Date: February 8th, 2023
Subject: Correction Notice #2
Project: 6221 83rd PI SE, Mercer Island
MI project # 2207-110

The following are issues and responses raised in the second Building Permit correction round:

**1 Section 4 Covered Deck**  
 SCALE: 1/4" = 1'-0"

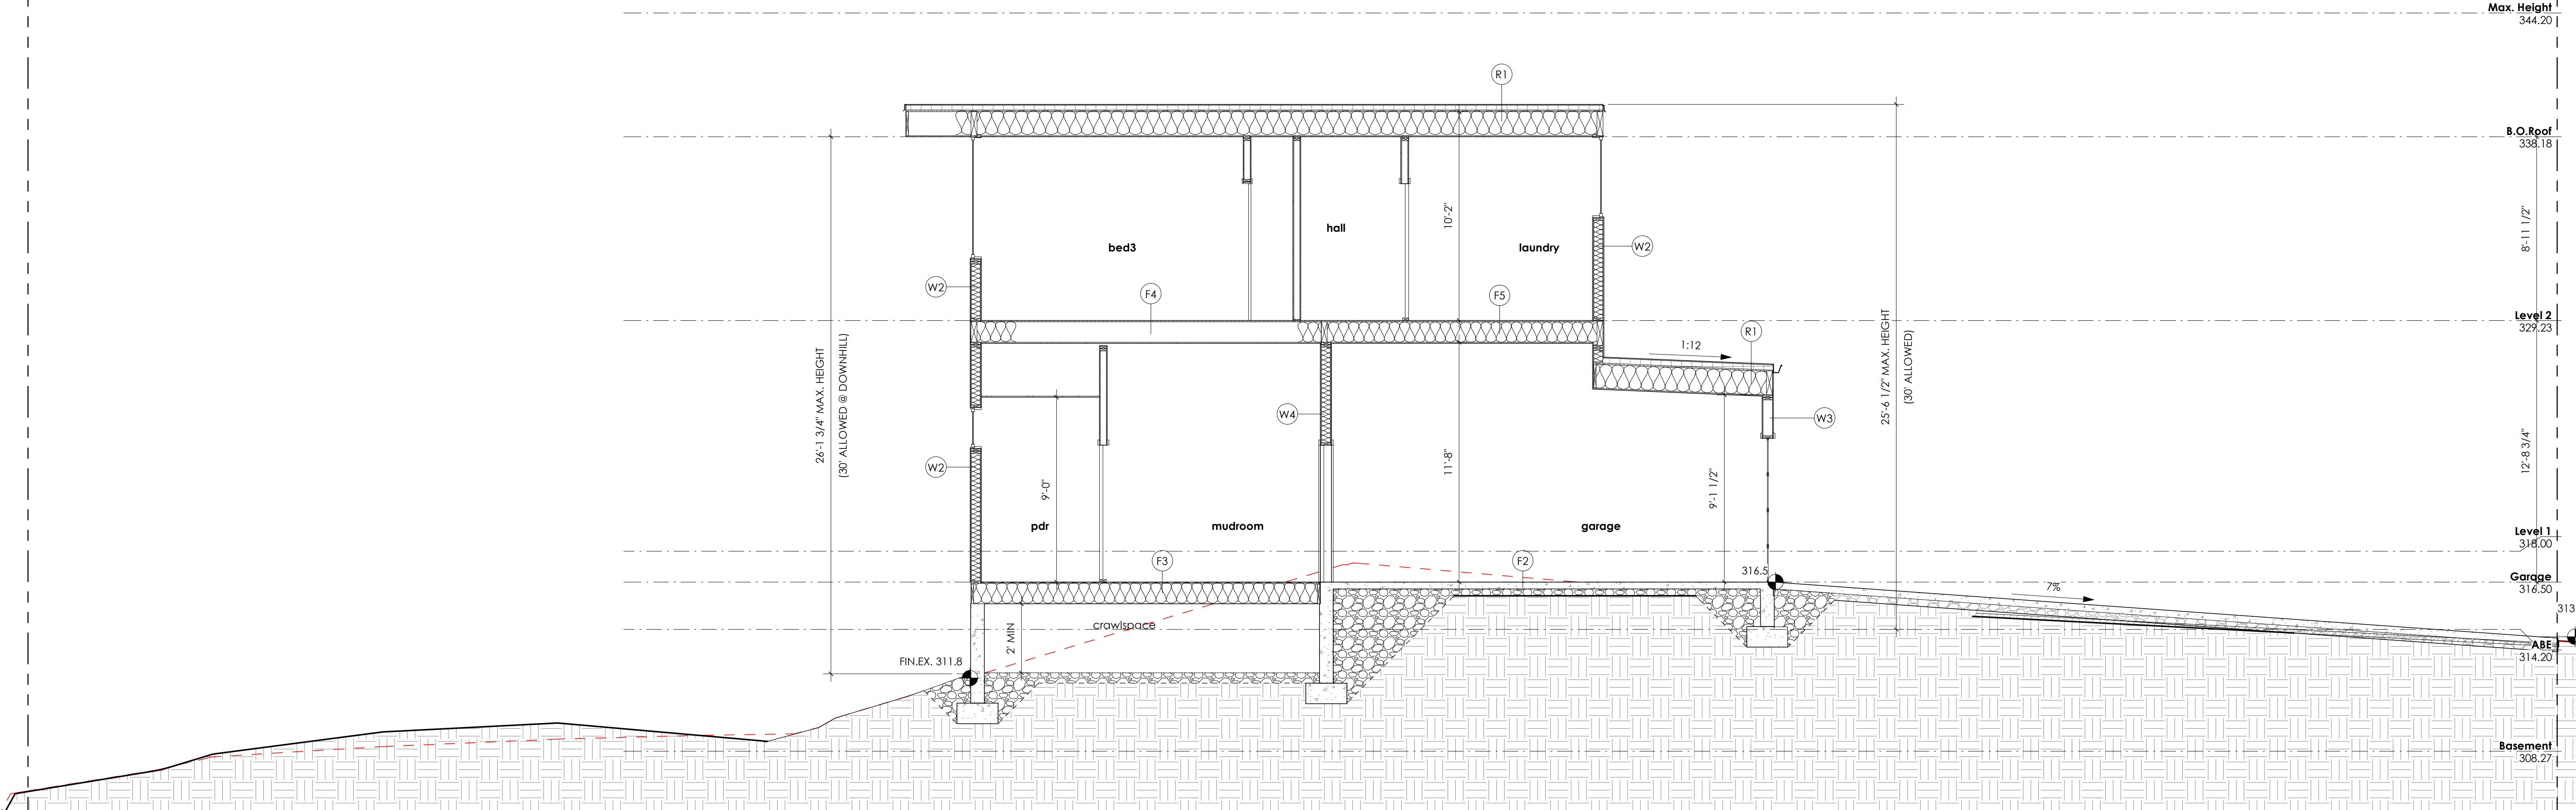
Sub2 Comment: Please note the manufacturer and model of the product, and confirm that the installation manual includes details for this application. If installation is not in conformance with a manufacturers' detail, provide a statement from the installer describing the installation procedure and warranty referencing the roof deck detail.

- a. Please see further product information noted on the roof assemblies on sheet, A4.1. Please see the statement uploaded from the installer describing the installation procedure and warranty referencing the roof deck detail. Thank you for your coordination.
